**DRAINAGE EASEMENT ANALYSIS  
FOR  
7950 MALLARD DRIVE**

August 2018

# **DRAINAGE EASEMENT ANALYSIS for 7950 MALLARD DRIVE**

DRAINAGE MAP

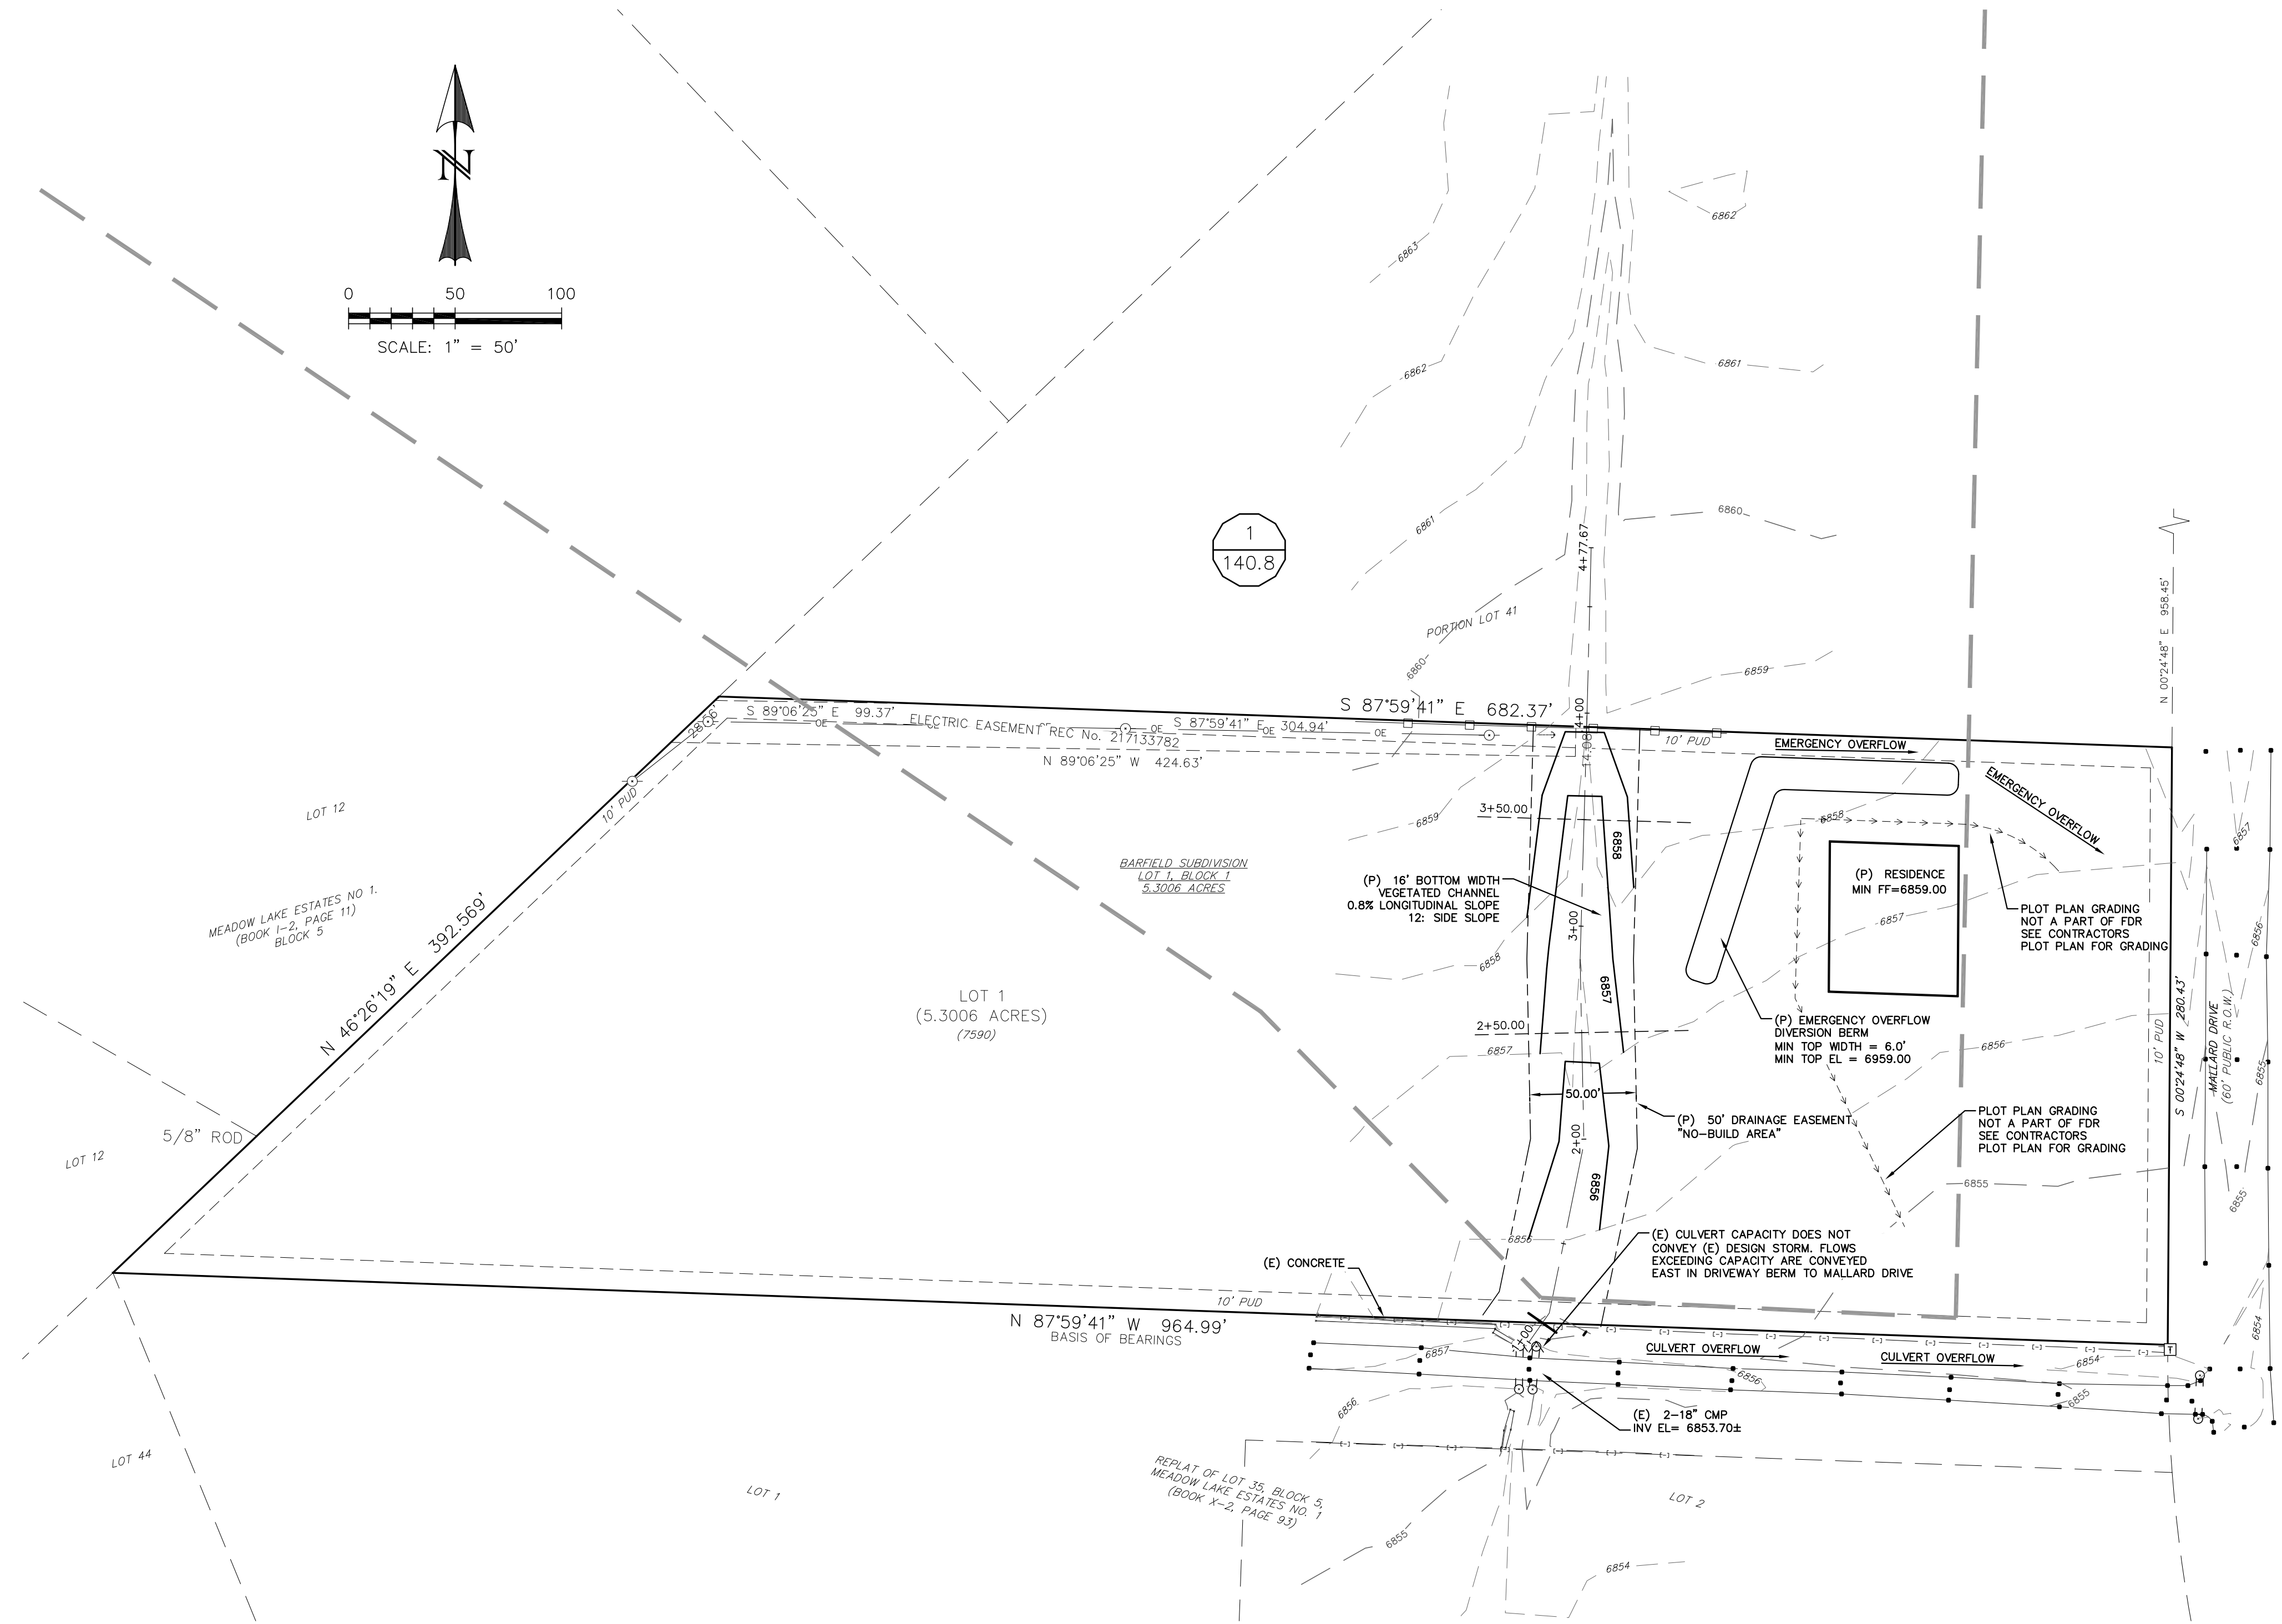
**Why not for the contributing  
area to the north as well?**

For undeveloped conditions?  
See comment letter.

Why not for the contributing area to the north as well?
